Rezoning Transportation Analysis

Petition Number: 2020-169

General Location Identifier: Tax ID: 15705424

Date	Description
11-30-20	First Review (WB)
12-28-20	Second review (WB)

DEVELOPMENT STANDARDS

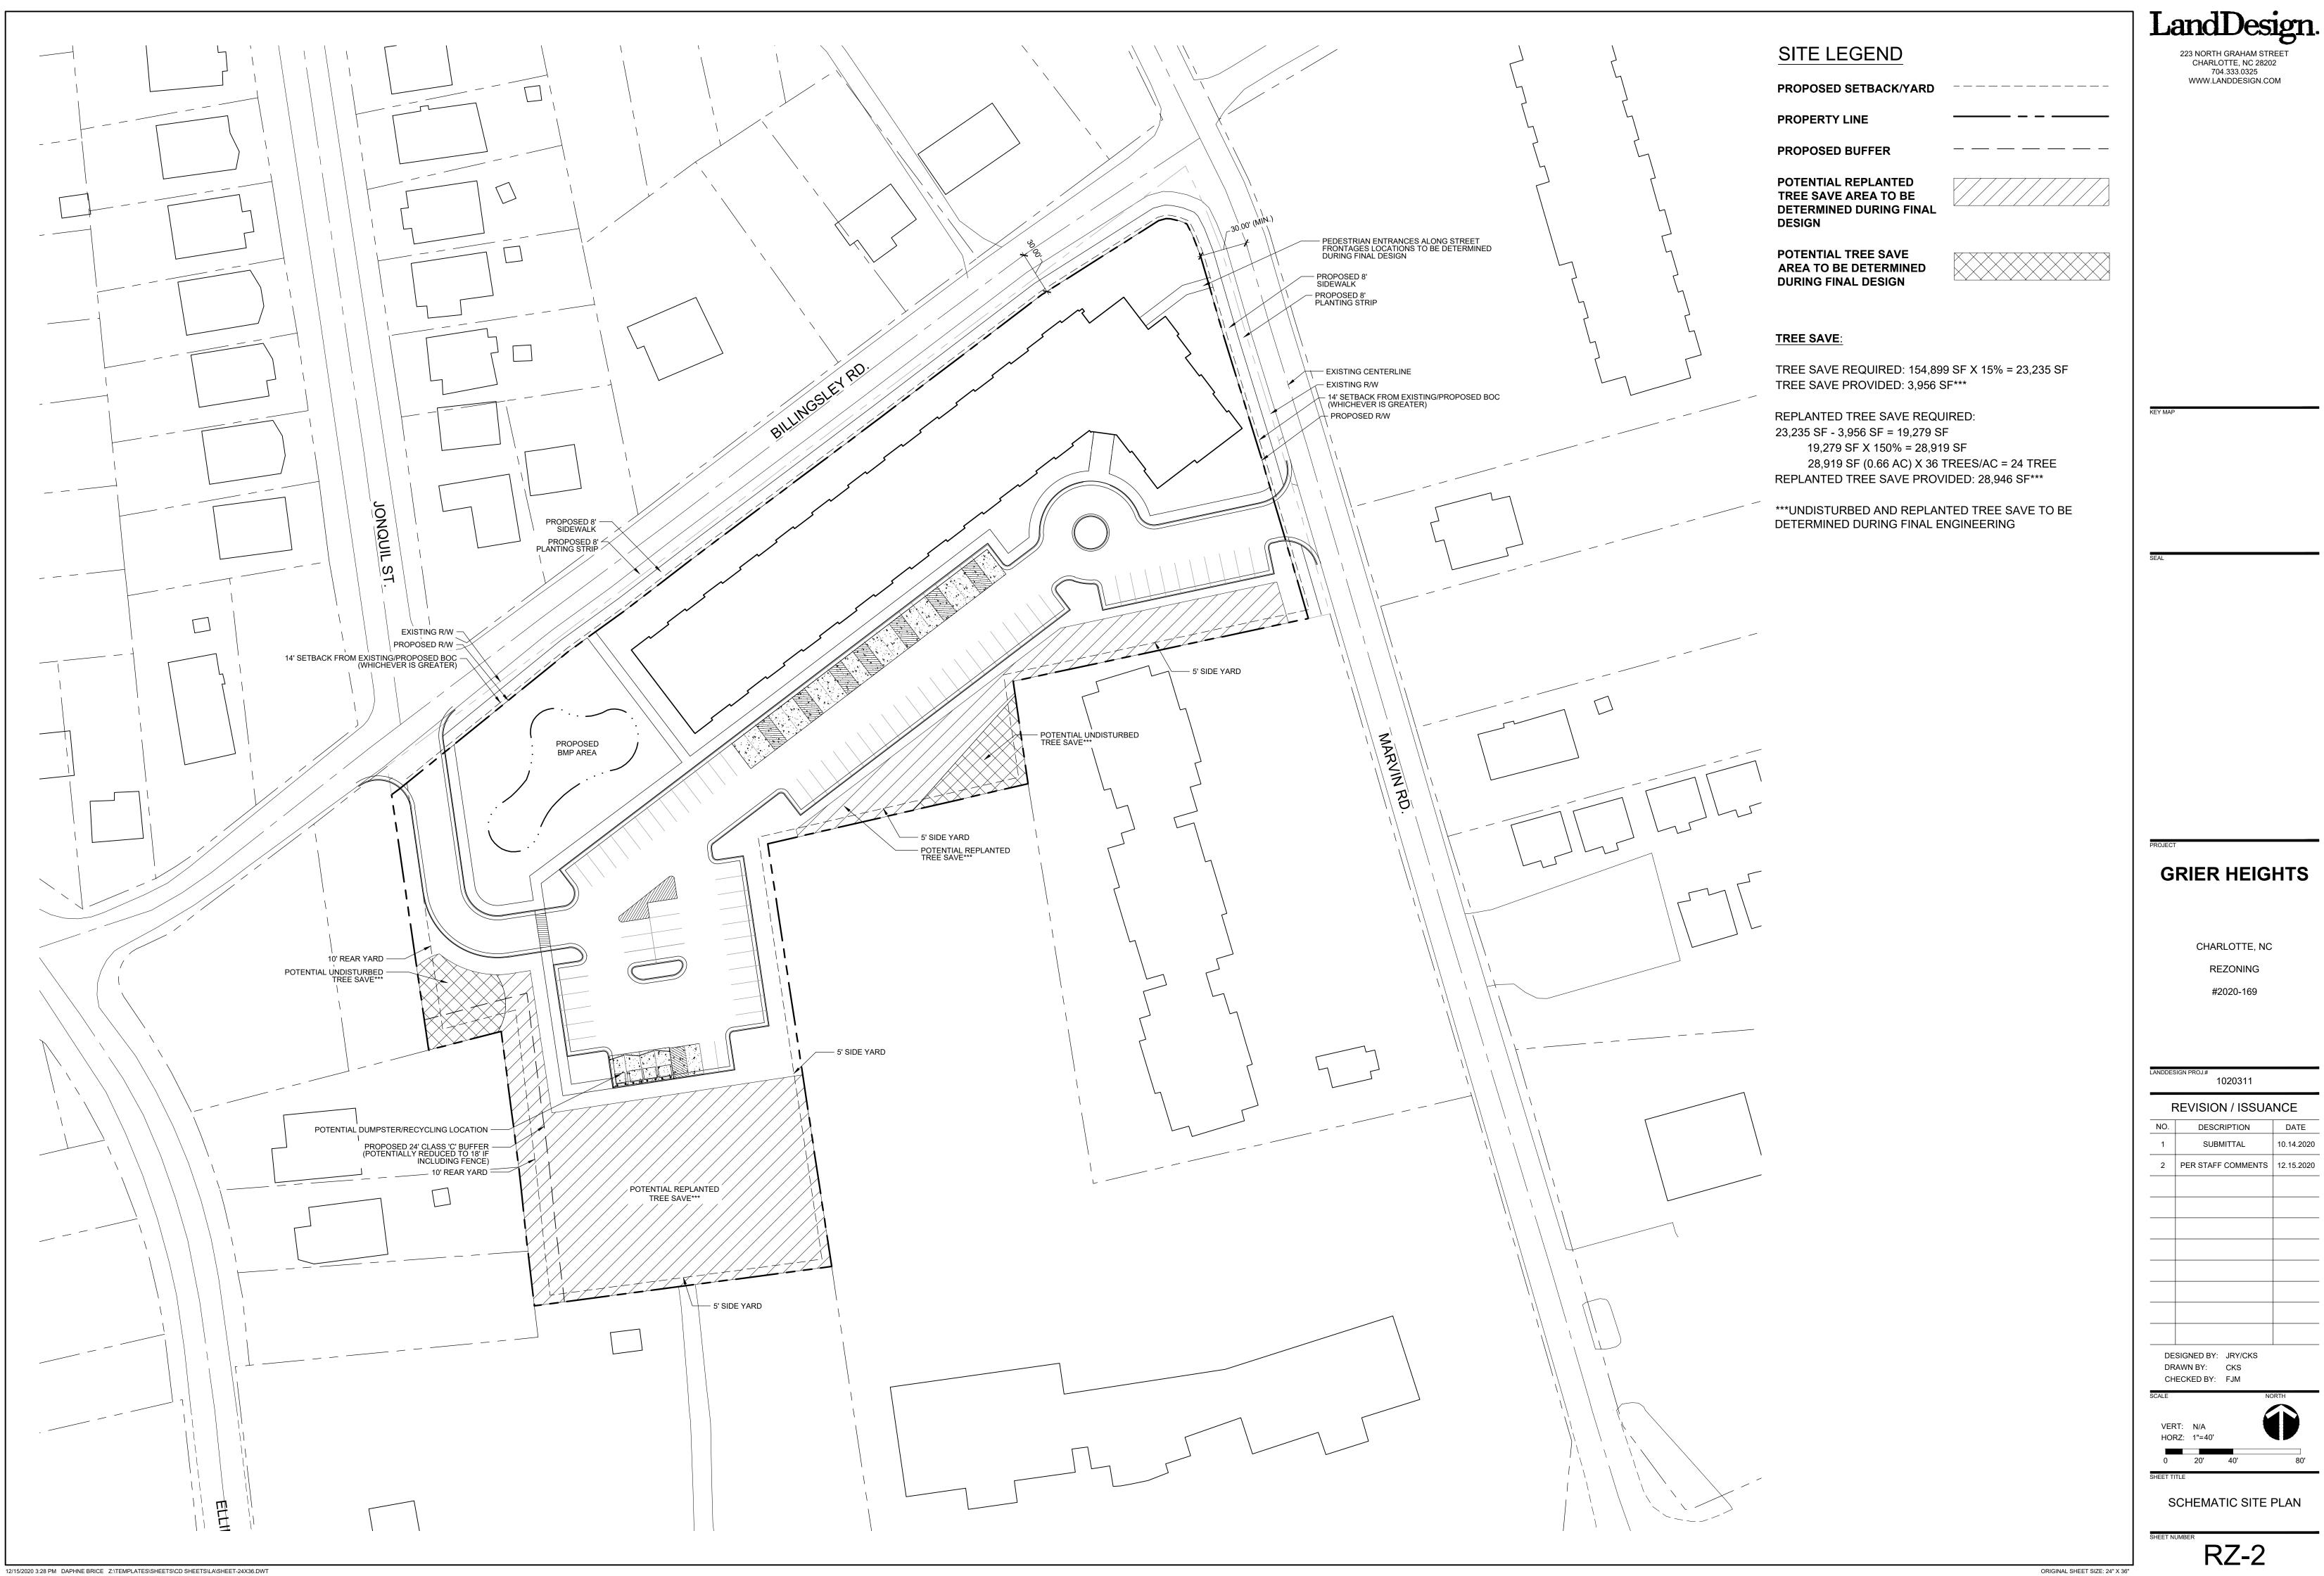
3. ~~Revise site plan and conditional note(s) to commit to dedicate 30' (minimum) right-of-way from the road centerline. The site plan shall label and dimension the right-of-way from the road centerline.~~

4. ~~The proposed dwelling units exceeds 12 per acre. Per Chapter 20 Subdivision ordinance, site plan and conditional note(s) revisions are needed to commit to construct an 8-foot planting strip, and 8-foot sidewalk along Billingsley Road and Marvin Road. The wider sidewalk also meets the Charlotte WALKS Policy.

Reference (CLDSM standard detail U-05) for street typical.~~
5. ~~Add a site plan note specifying dedication and fee simple conveyance of all rights-of-way to the City before the site's first building certificate of occupancy is issued is needed. CDOT requests rights-of-way set at 2' behind back of sidewalk where feasible.~~
6. ~~Add a site plan note specifying that all transportation improvements will be approved and constructed before the site's first building certificate of occupancy is issued is needed. The petitioner may phase transportation improvements if said improvements and phasing are explicitly described in site plan notes.~~
